**KIRKLEES METROPOLITAN COUNCIL
INVESTMENT & REGENERATION SERVICE**

| Reference No: | 2024/62/92652/W |
| Site Address: | 177, Moor End Road, Lockwood, Huddersfield, HD4 5HJ |

Officer Report – 2024/92652

**Proposed Ground Floor Plan
& Block Plan Scale 1:100**

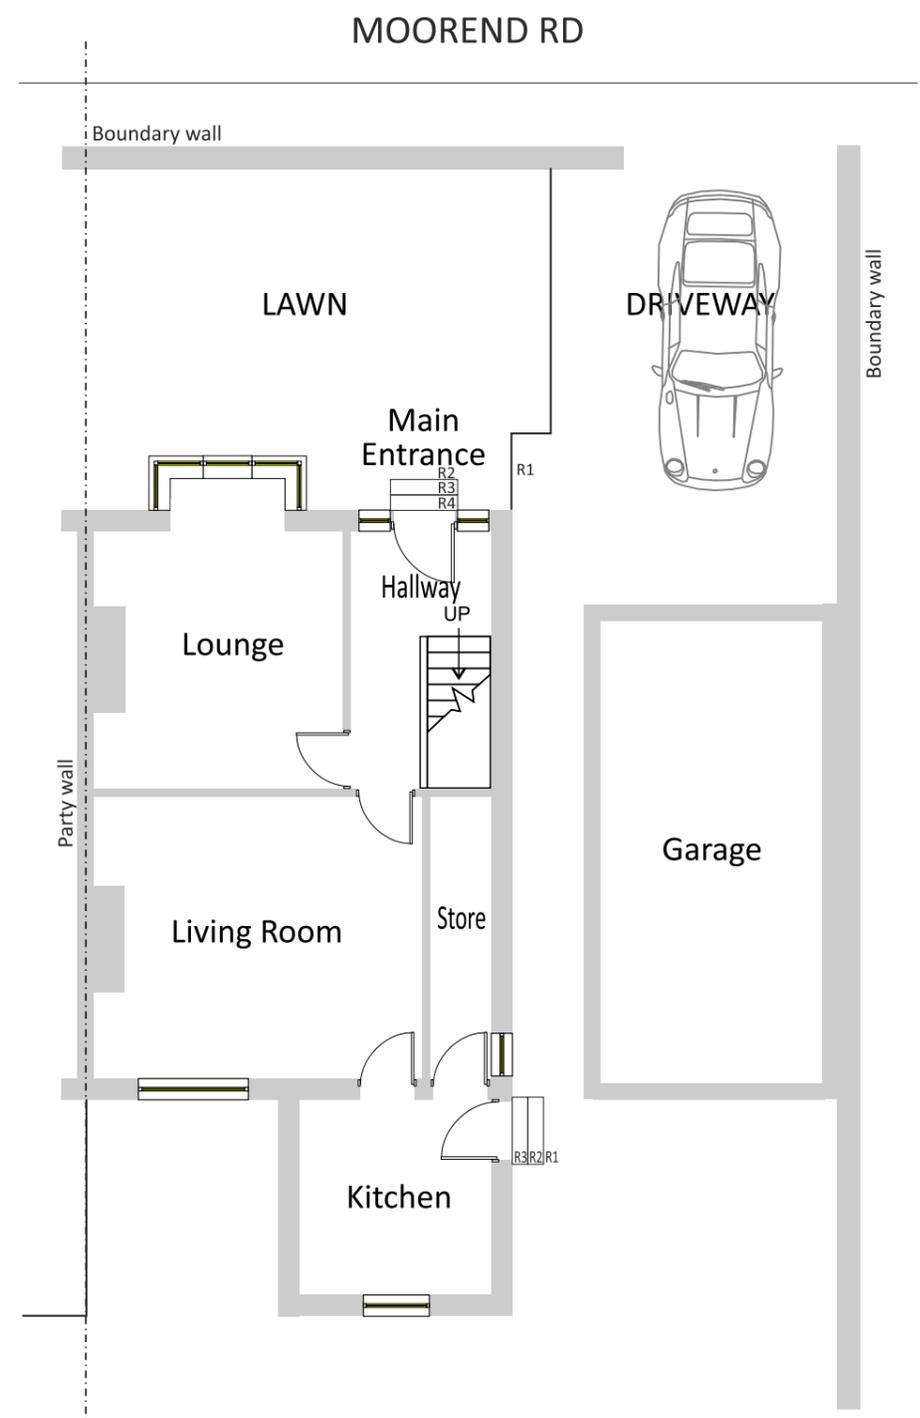
However, the proposed two storey side extension lies flush with the front elevation of the original property rather than being set back 500mm, as required to comply with the House Extensions and Alterations SPD. This considered, the property does lie within a varied street scene. Furthermore, the side extension lies within 1m of the site boundary, leaving a gap of only 0.91m rather than the 1m required to comply with the House Extensions and Alterations SPD.

The proposed rear extension also does not entirely comply with the supplementary planning guidance regarding house extensions, extending 3.13m from the rear elevation of the original building where only 3m is allowed. Moreover, where rear extensions project further than 3m, their eaves height must not surpass 2.5m, and the proposed extension on this site would have an eaves height of 2.9m. The maximum height of the extension would

also surpass what is complaint with the House Extensions and Alterations SPD at 4.2m, rather than the suggested 4m. Finally, as the rear extensions is set to project outwards of the side elevation of the original building, the gap to the side boundary is also only 0.91m from this proposed extension, rather than the 1m required to comply with the House Extensions and Alterations SPD.
